Application number: 2020/94189	
What is the application for?:	Erection of single storey rear extension
Address of the site or building:	16, Yew Green Avenue, Lockwood, Huddersfield, HD4 5EW
Postcode:	HD4 5EW

User comments

Elevations as Proposed				
Date:	Scale:	Project No.	Dwg. No.	Rev.
May 2020	1:100 @ A3	082	04	A
Purpose of Issue: Planning

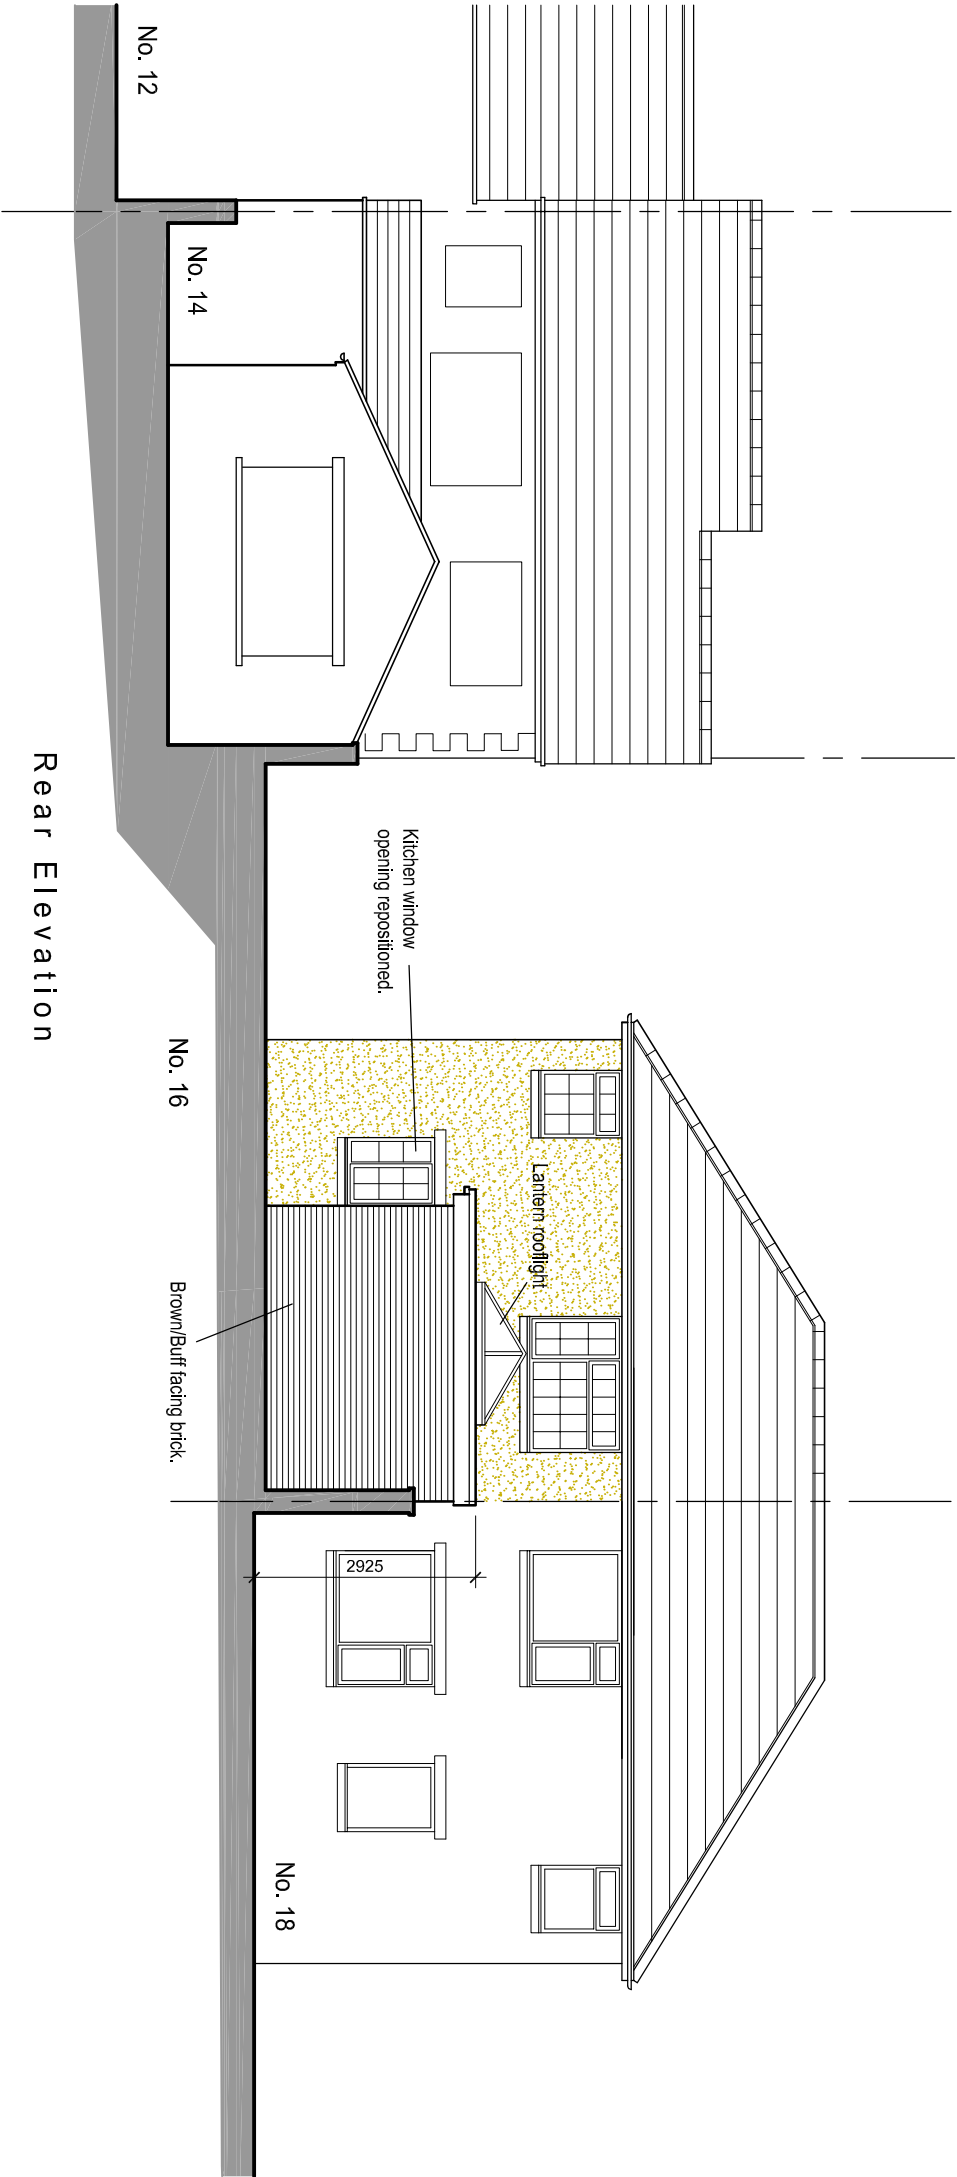
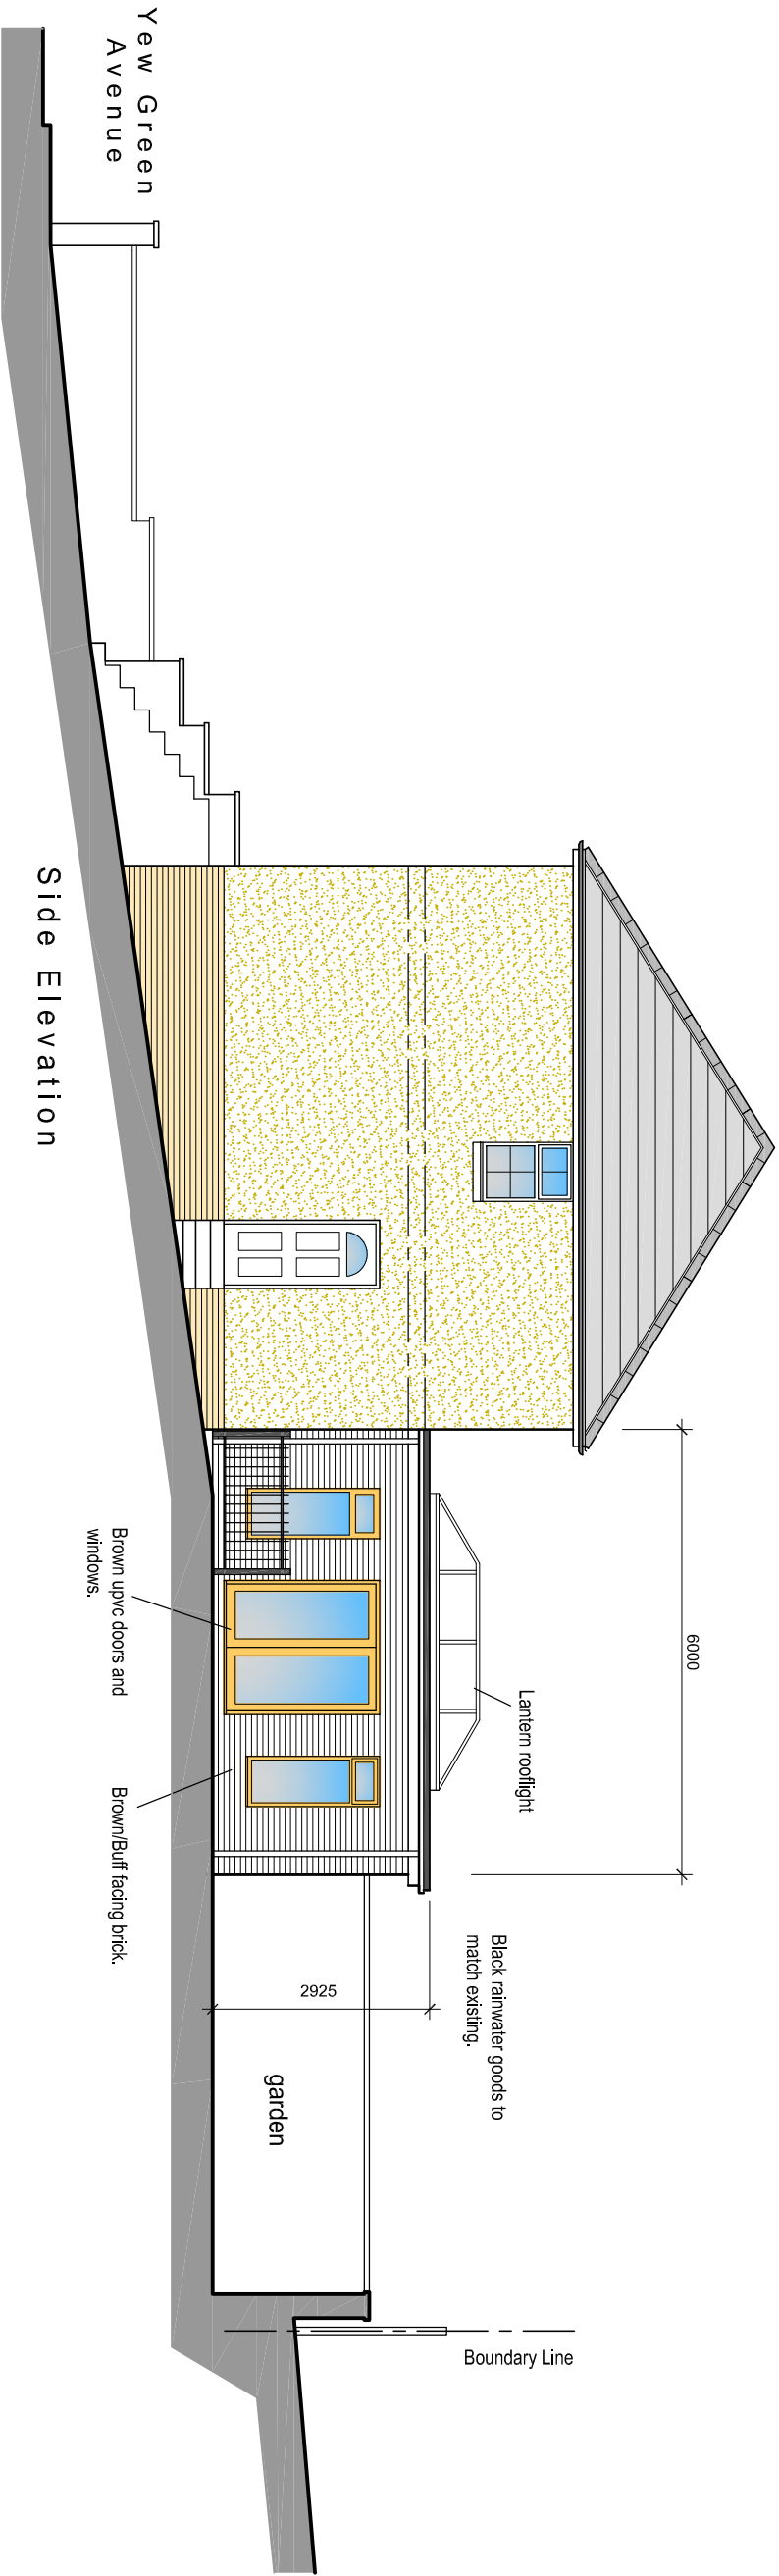
Type of comment: An objection
The design, size and appearance is imposing and not in keeping of the landscape around, it is clearly far too big. 6m is far too much and excessive for what is required or acceptable. It will have a substantially negative and detrimental effect on the character of the area. It will add significantly to the noise and disturbance in the area. It will have a significantly negative and detrimental effect on my living conditions, especially the added light from the lantern lighting and the additional external lighting. This lantern sky light is far too big and imposing and will shed too much and excessive light against my 1st floor bedroom window. Thereby causing me disturbance and a nuisance with my sleep during the night hours. This will have a significant negative and detrimental effect on my health and well being. It will have a substantially negative and detrimental effect on the sunlight and daylight for me during the daytime, it will cause significant shading and sunlight blocking onto my property and my garden and privacy, it will encroach on my privacy and of other neighbours and I will be overlooked significantly and far too much. It will have a significantly negative and detrimental effect on mine and my neighbouring properties especially with house prices, this will degrade, devalue and lower our property values. The building will look an eyesore and a blot on the landscape. The design and boundaries encroach onto my land and garden, there must be a significant distance from the wall to my wall and garden boundary. I request that you reject this planning application outright as it is inappropriate.
